DRAFT BCA ASSESSMENT REPORT

*Scape Eveleigh - 175-177 Cleveland Street, 1-5 and 6-8
Woodburn Street*

Project number 252955
Revision: Draft_BCA 1.0
Date: 15 December 2025

PROJECT:
PROPOSED CO-LIVING DEVELOPMENT
175-177 Cleveland St and 1-5 & 6-8 Woodburn St, Redfern
DRAWING:
LEVEL 5 PLAN

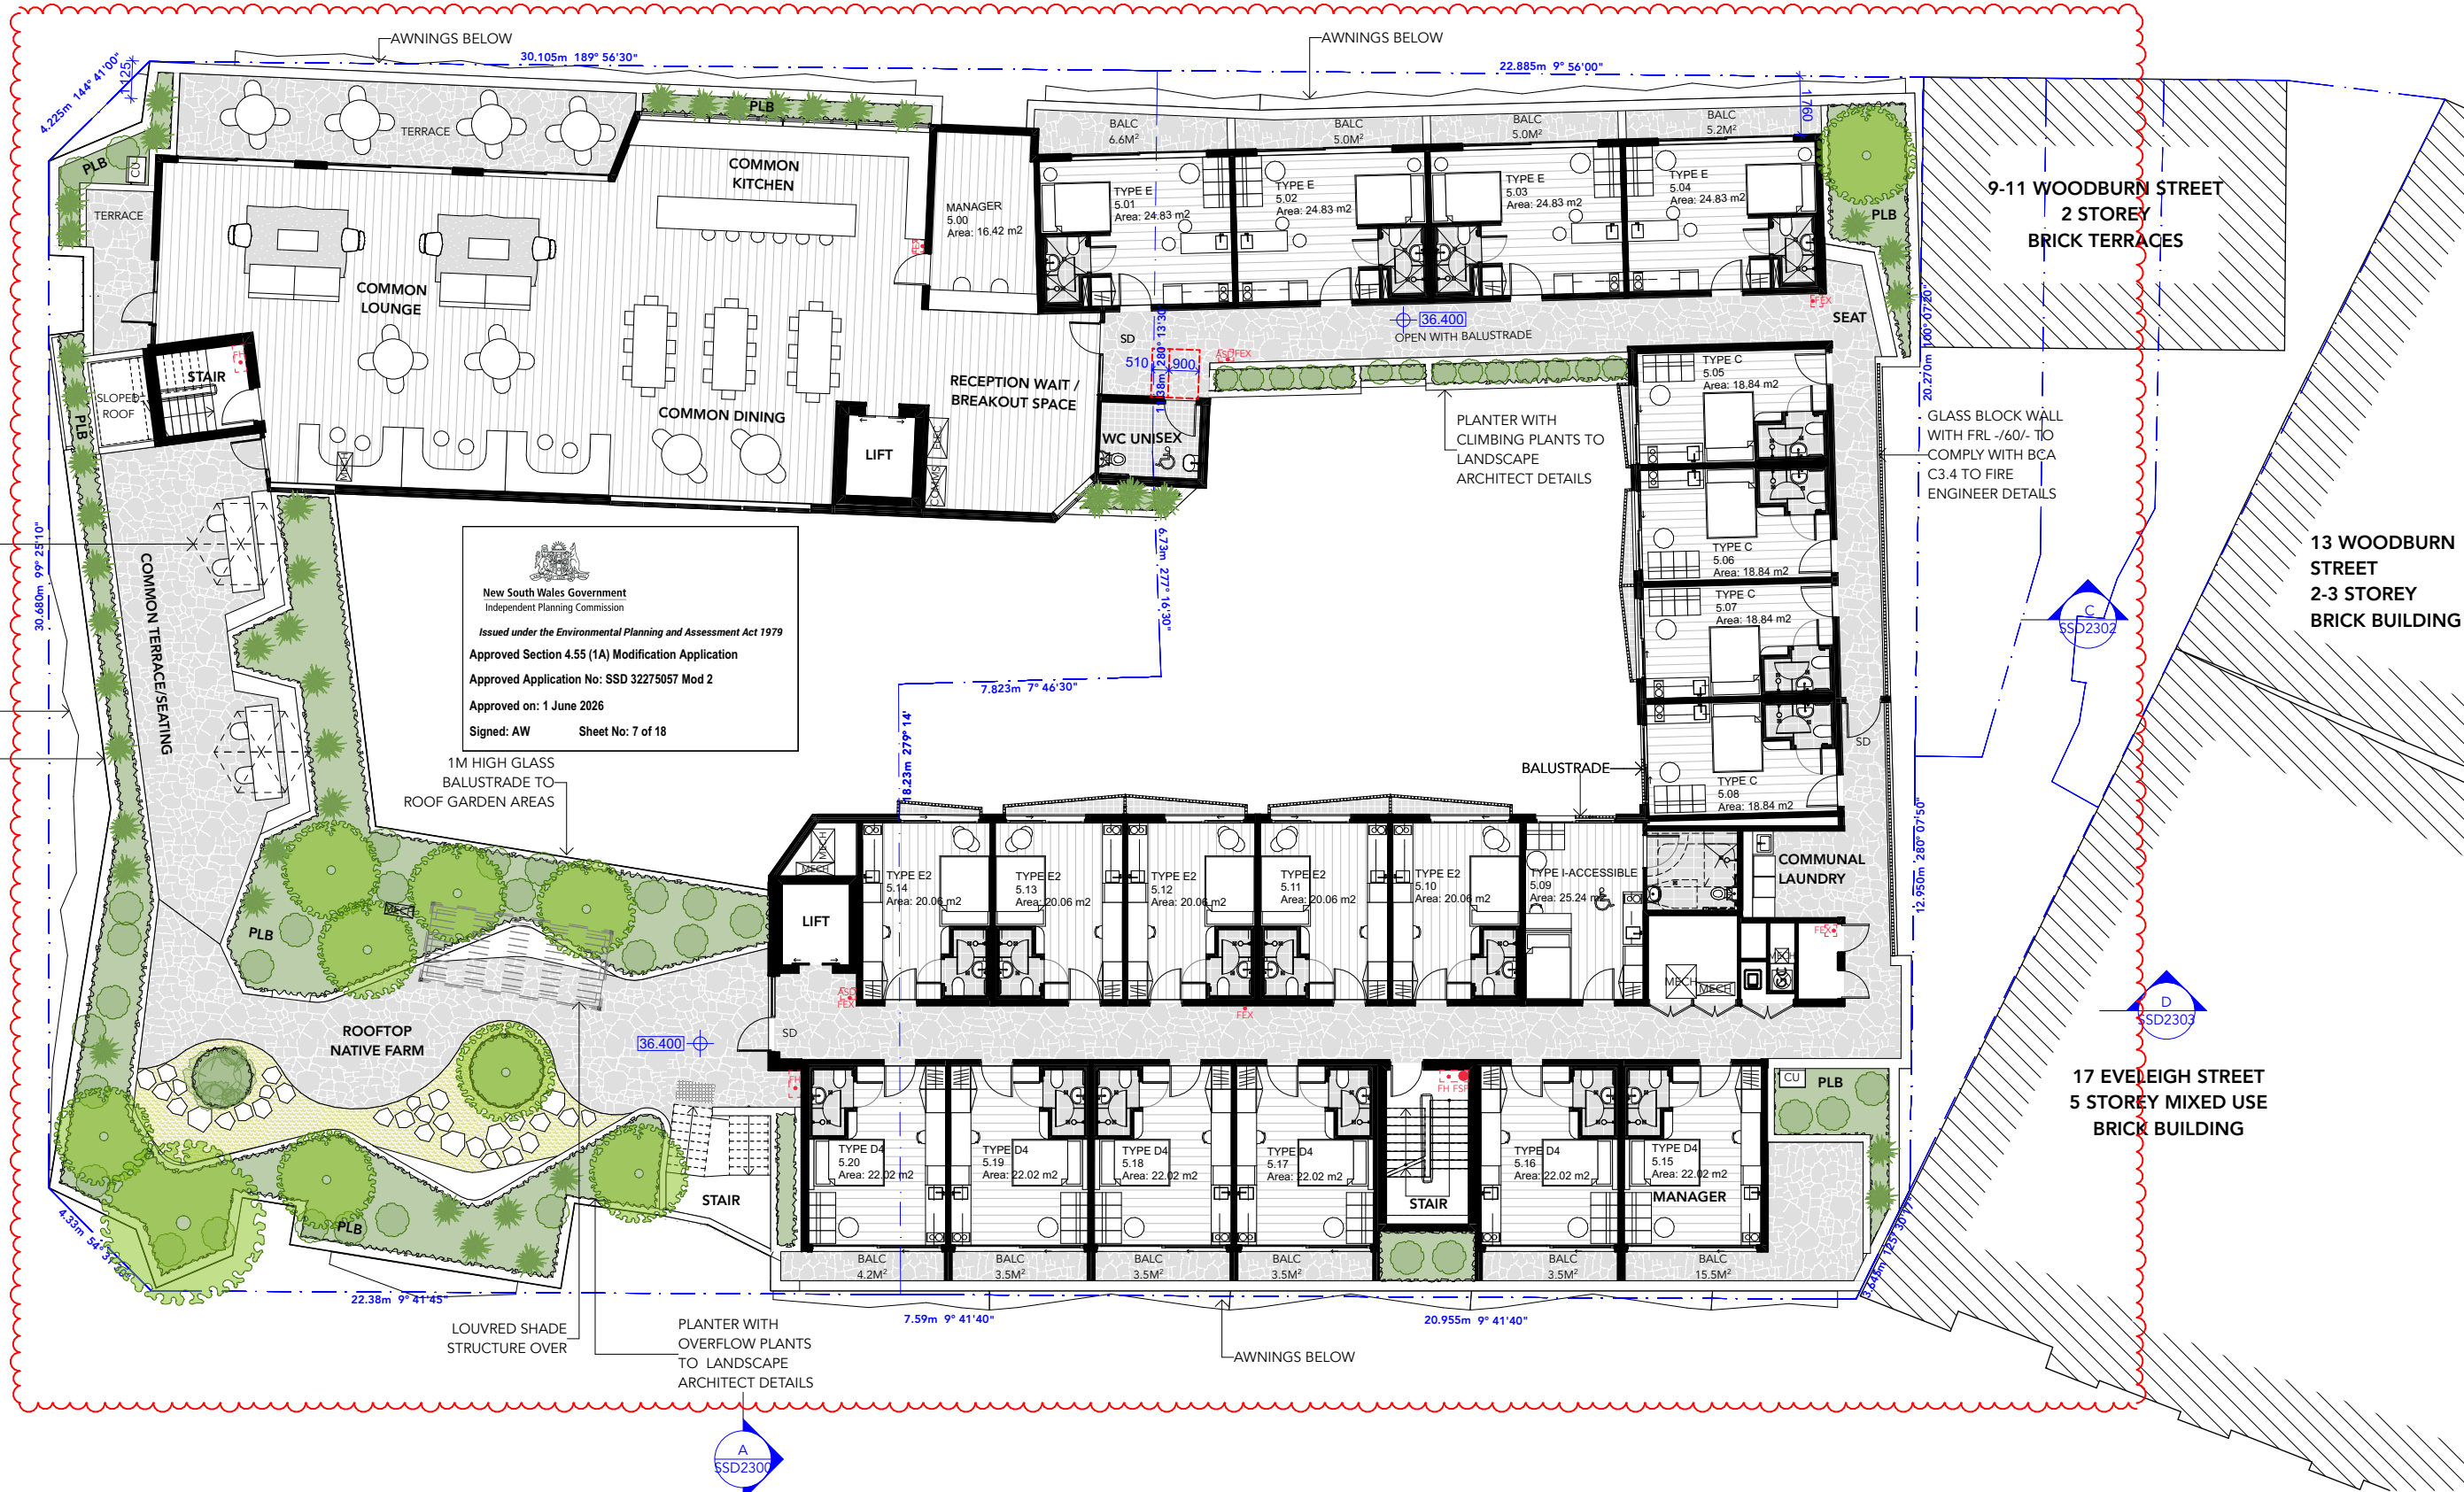
3.	The seating proposed at the terrace location on Level 5 may incorporate horizontal or near horizontal elements that could facilitate climbing between 150mm and 760mm above the floor. Confirmation to be provided to ensure compatibility issues are addressed in design or alternatively, a non-fire engineered performance solution to be sought.	Clause D3D20
